**SYDNEY WATER DEVELOPMENT
CIVIC PLACE, PARRAMATTA**

OBJECTIONS

Figure 7 – Proposed vehicular access to south-western corner of Sydney Water building (original scheme).

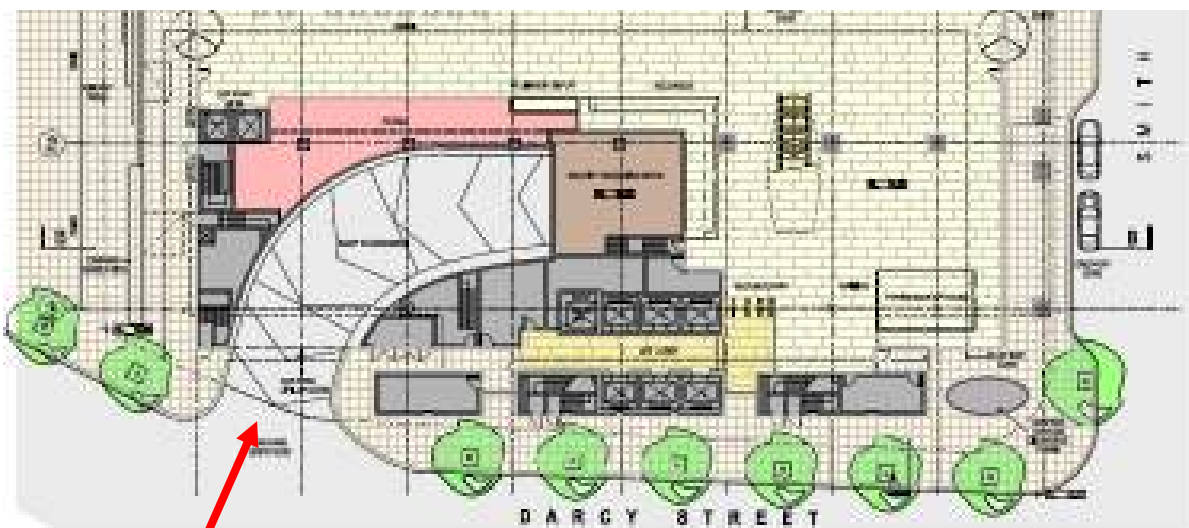
movement of vehicles down an access ramp in Darcy Street makes no cognisance of site boundaries and would appear to require use of Sydney Water land along Darcy Street frontage in order for the ramp to access to below the proposed retail arcade level. No discussion has taken place to date on this issue with SWC or its selected developer, Multiplex Capital. Similarly, the orientation of the Sydney Water building appears to have been modified in the Parramatta Council/Grocon Civic Place proposal without reference to SWC and the building's context with Smith Street and Civic Place. Concern has been expressed by Sydney Water over the potential for the development of Civic Place to be delayed for a lengthy period of time, subject to the market demand for the proposed mixed development. In terms of responding to the planning controls, the Sydney Water proposal meets the requirements of SREP 28.

2	Grocon	The failure of the Development Application to accommodate the extensive master planning carried out in respect of the Parramatta CBD is most fundamentally demonstrated by the fact that whilst the proposed SWC building relies on access from Darcy Street, Parramatta City Council has as part of its vision for Civic Place, obtained the approval of the Department of Local Government to compulsorily acquire the public road comprised in Darcy Street (the effect of which will be discontinuance of the use of this land as a road). This action on the part of Council (and the approval given by the Department of Local Government) unequivocally recognises the need for Council and associated stakeholders to invest in properly master planned outcomes for central Parramatta CBD and the Civic Place site (and, furthermore, this investment has already been	The Sydney Water design proposal has been designed within the context of the adopted and gazetted Civic Place Master Plan (CPMP) 2003 and SREP 28. The draft LEP and DCP referred to in the commentary had not been released at the time of concept design and are yet to be adopted. The publicly gazetted Civic Place Master Plan (CPMP) 2003 document envisaged vehicular access along Darcy Street, with a turn around, prior to accessing a ramp structure to basement parking under Civic Place. Working within the context of the available and adopted master plan information, the Sydney Water concept design illustrates a significant 'investment' in master planned design outcomes works referred to by the objector without

CPMP Section 6.13 of CPMP states that vehicle access is to be via Macquarie Street or Smith Street and that Darcy Street is to be closed to through traffic and function as a drop off/pick up area in the future. The proposed development does not comply with this requirement in that the only vehicular access is provided off Darcy Street via a very wide driveway. As has been identified above, this non-compliance has the potential to impact on the activation of the Darcy Street frontage and the safety and security of pedestrians in the area. Access for vehicles, including trucks and delivery vans off Darcy Street conflicts with this planned street closure and the ability of Darcy Street to function as a safe drop off/pick up point.	The adopted Civic Place Master Plan (CPMP) 2003 clearly envisaged that Darcy Street be retained in part of its length for the purposes of providing vehicular access to basement parking areas. As such this length of retained roadway was envisaged to function as a service access and drop-off as illustrated in Figure 7.10 of CPMP 2003. The concept proposals released by Parramatta City Council/Grocon continue to adopt the intent of the gazetted statutory instruments that the partially retained Darcy Street acts as a service corridor for basement access and drop-off purposes.

86	Parramatta Council	City	Inappropriate Location of the Vehicle Entry Point & Excessive Width in Darcy Street – ▪ The re-location of the Sydney Water entry point away from Smith Street and into Darcy Street forces a greater number of traffic movements into the internal street system. ▪ Ideally Sydney Water should take advantage of the Civic Place proposal to share access in a Darcy Street portal with the main development for both parking and servicing and access to retail. ▪ Further the Stage 1 DA provided a 6.8m driveway access to Smith Street. The current proposal has provide a 10m wide carpark entry on the visual axis with pedestrians exiting Parramatta Station to the square and interrupting pedestrian desire line along the edge of the building connecting with Darcy Street.. The 10m width which is visually unattractive, interrupts unreasonably pedestrian footpath areas and does not comply with the requirements of SREP 28. ▪ Relocation of the vehicle entry from Smith Street into Darcy Street Plan portal location as well as being on the major visual axis for pedestrians from the station. ▪ The additional traffic imposed on the Smith/Darcy Street intersection will adversely impact on the accessibility of vehicles and pedestrians from the east into Civic Place and drop off for the Rail Interchange. There has been no modelling provided with the Stage 2 DA which reflects this increased vehicular movement.	The combined entry/exit vehicular point proposed to Darcy Street is located east of the north-south link such that there is no conflict between pedestrians and traffic. The width of the entry is required to accommodate all vehicles, including delivery vehicles. This will enable all vehicular activity to be confined to within site. Vehicular entry off Smith Street is impractical due to the design constraints to the Smith Street façade and the traffic flows along Smith Street. Section 6.13 of the CPMC states the Darcy Street will provide for servicing and car parking access to the Civic Place site. In this regard, the proposed access to the Sydney Water building is consistent with the CPMC. Design and timing constraints also provide an outcome that access from Darcy Street is the most appropriate outcome.
